DECISION DELEGATED TO HEAD OF PLANNING

Application No: H16-0801-25 **Applicant:** Castle Events Limited

Proposal: Installation of two exterior illuminated signs on the front railings - Retrospective

Location: The Sessions House Sheep Market Spalding

Drawing Title: Front Elevation
Drawing Number: SH-SIGN-002

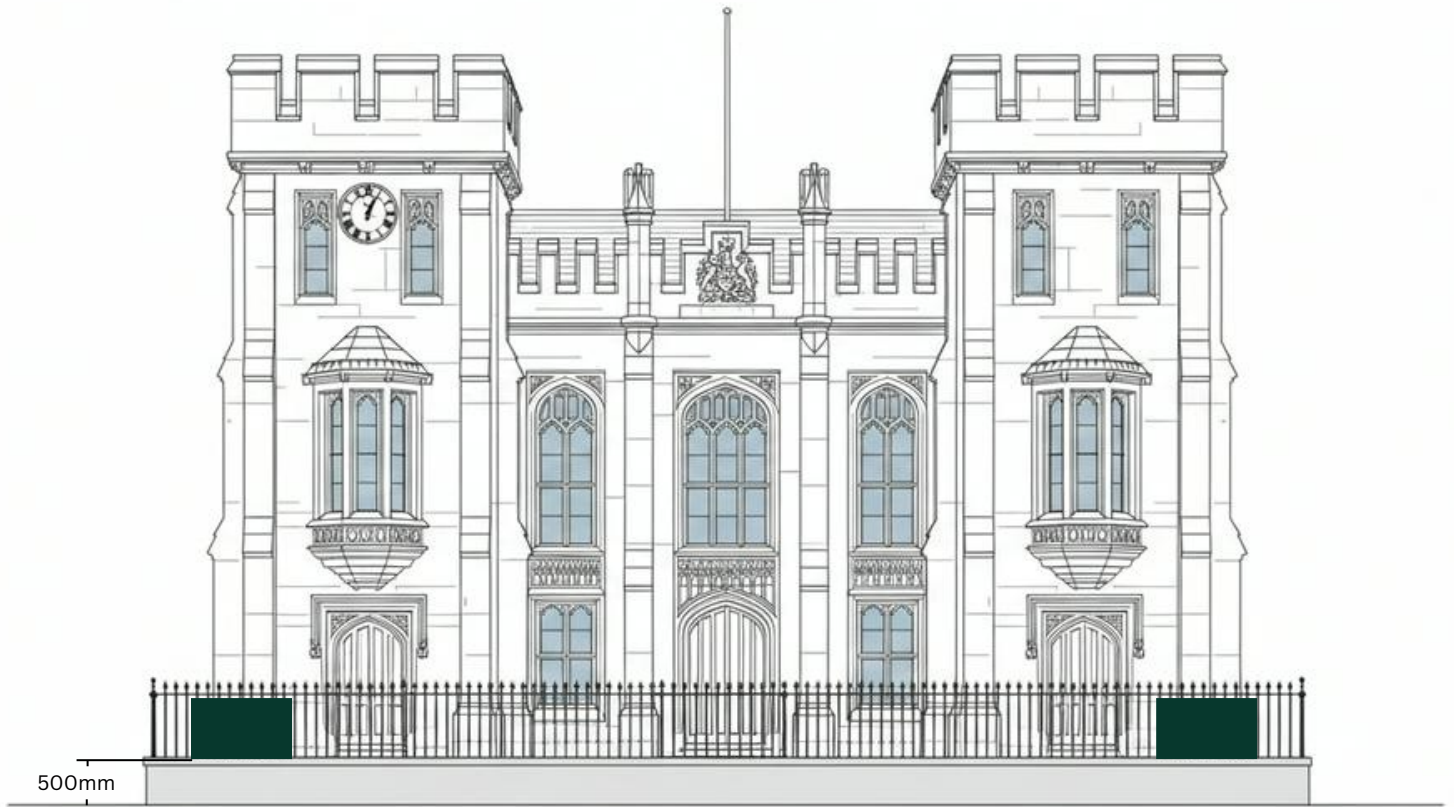
The signs are located across the railings which bound the site, and are situated to the front boundary of the grade II listed building and as such, lie within the most prominent and important view of the grade II asset.

As such, the advertisements are highly visible when travelling along Sheep Market and the surrounding area; which itself forms a prominent and important character historically. As outlined above, the signs feature a white background with gold lettering, with the lettering in particular being internally illuminated. The signs themselves are prominent within the street scene, as outlined above, being fixed directly onto the railings towards the principal elevation of the building, within close proximity to the footpath.

Whilst the sign has been fixed in a non-invasive method with a long metal strip being placed across the back of the signs and secured using metal clips with the Conservation Officer discussing that it does not require the removal of any historic railings and could be easily reversible, the lack of physical harm does not neglect the evident harm arising from the proposal as discussed above.

Drawing Title: Proposed Signage
Drawing Number: SH-SIGN-001

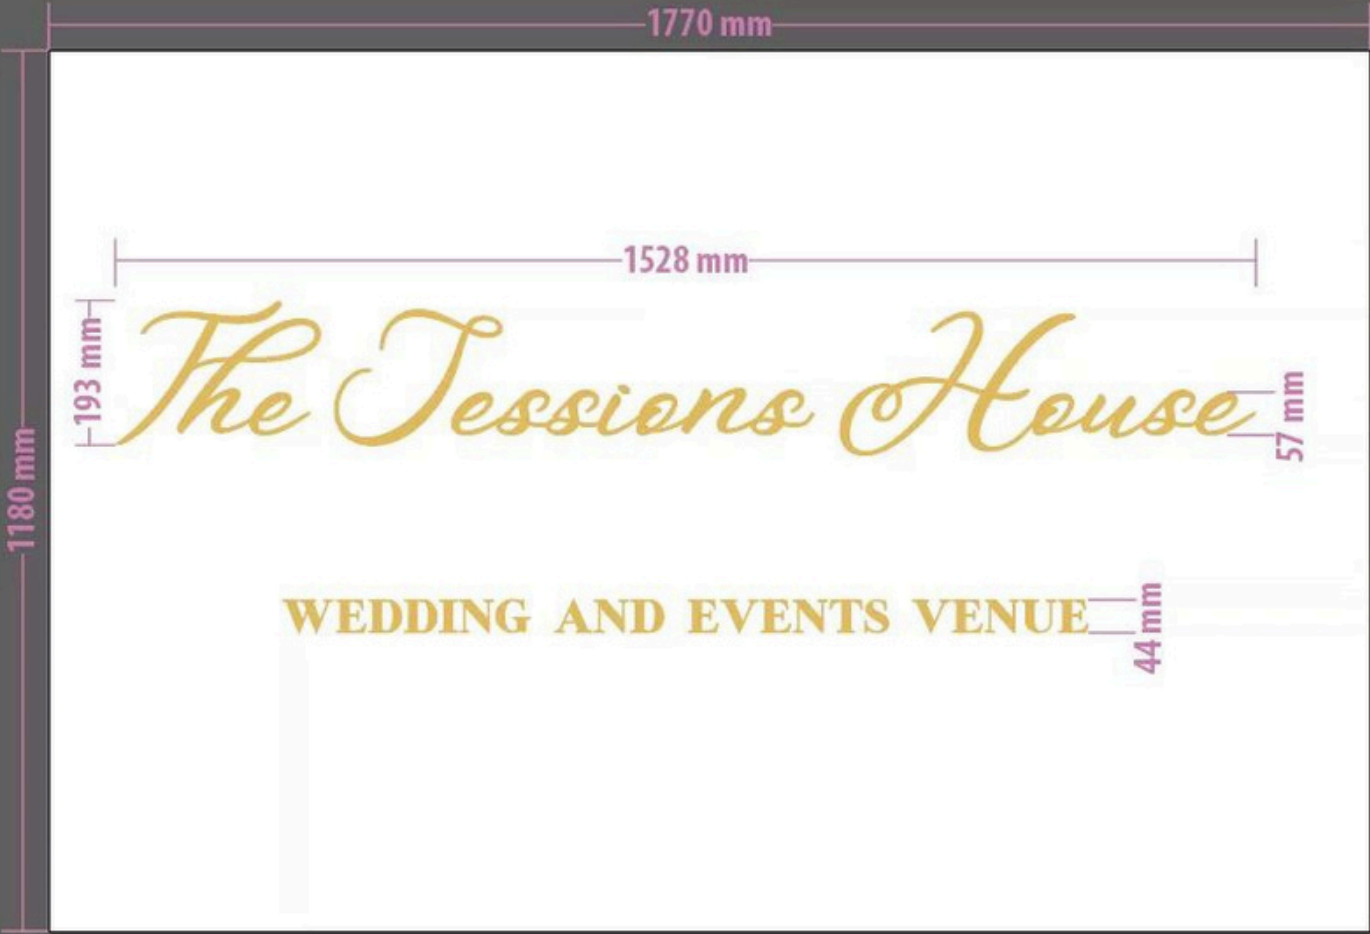
The signage does not complement the character or special interest of the Sessions House. Its design is overly simplistic and contemporary when compared with the building's highly decorative architecture and the ornate railings behind it.

The positioning of the sign is not considered to be inherently harmful. It does not require the removal of any historic railings and appears to be easily reversible. However, the sign is excessively large and out of proportion, particularly given the limited amount of text it contains. This could be addressed by reducing the overall scale of the signage to achieve a more balanced relationship with the host building.

Furthermore, the white background is visually intrusive and appears out of keeping with the historic character of the building. Its stark appearance draws unnecessary attention to the sign itself, rather than allowing it to sit comfortably within its surroundings. Effective signage should attract attention through high-quality design that complements and enhances the character of the heritage asset and its setting, rather than competing with it.

Additionally, the site lies within the Spalding Conservation Area, and we are unable to support the proposed internally illuminated signage, as it is considered to be out of character with the historic nature of the area. Section 72 of the Planning (Listed Buildings and Conservation Areas) Act 1990 requires that "special attention shall be paid to the desirability of preserving or enhancing the character or appearance of that area." The proposed signage fails to preserve or enhance the character and appearance of the Conservation Area for the reasons set out above. Furthermore, the inclusion of internally illuminated lettering introduces an unnecessarily prominent and modern feature that detracts from the historic significance and visual quality of the area. The illumination itself is particularly conspicuous, with the harsh white light drawing undue attention to the signage rather than allowing it to sit comfortably within its historic surroundings. A more sympathetic design would better preserve and enhance the character and appearance of both the Conservation Area and the setting of the Sessions House.

The Control of Advertisement Regulations 2007 cover the conditions for which consent for advertisements should be given. Illuminated advertisements in conservation areas are specifically prohibited with the Classes included within Schedule 3, Part 1. Furthermore, the dimension of each board at 2.088 sq metres exceeds the maximum of 1.55 sq metres set out within class 5 of the regulations.

It is considered that the white background would introduce a unsuitably stark and unsuitably contrasting addition, which is visually intrusive and appears out of keeping with the historic character of the building; particularly when viewed against the black railings to which they would be fixed. This is supported through the objection raised by the Council's Conservation Officer, who outlined that the white background appears *"visually intrusive"* and *"out of keeping with the historic character of the building"*.

In addition, it is also considered that the design, through the overall proportion and sizing illustrated, would introduce a harmful and detrimental addition. The advertisements are of an excessively large scale failing to appear proportionate for its context, with the text including on such further exacerbating and highlighting the unnecessary scale of the advertisement board itself.

Not only are there significant design concerns, there are also concerns relating to the internal illumination aspects featured within the lettering. Internal illumination is considered to be wholly unacceptable within such a heritage setting, resulting in a juxtaposing nature, which is even more pertinent when taking into consideration the listed nature of The Sessions House.

The sign could be metal or timber and hang over the existing railings, with a painted cream background to provide a softer, more traditional appearance. The lettering could either be hand-painted or formed from individually cut letters. If illumination is necessary, this could be achieved through discreet, warm-white lighting around the border of the sign rather than internally illuminated lettering (para.208 NPPF). Such an approach would achieve a high-quality design that meets the operational needs of the business, including the provision of illumination where required, while also enhancing the setting of this prominent listed building and preserving the character and appearance of the Conservation Area. It would better reflect the architectural quality and significance of the heritage asset and represent a more sensitive response to its historic context.
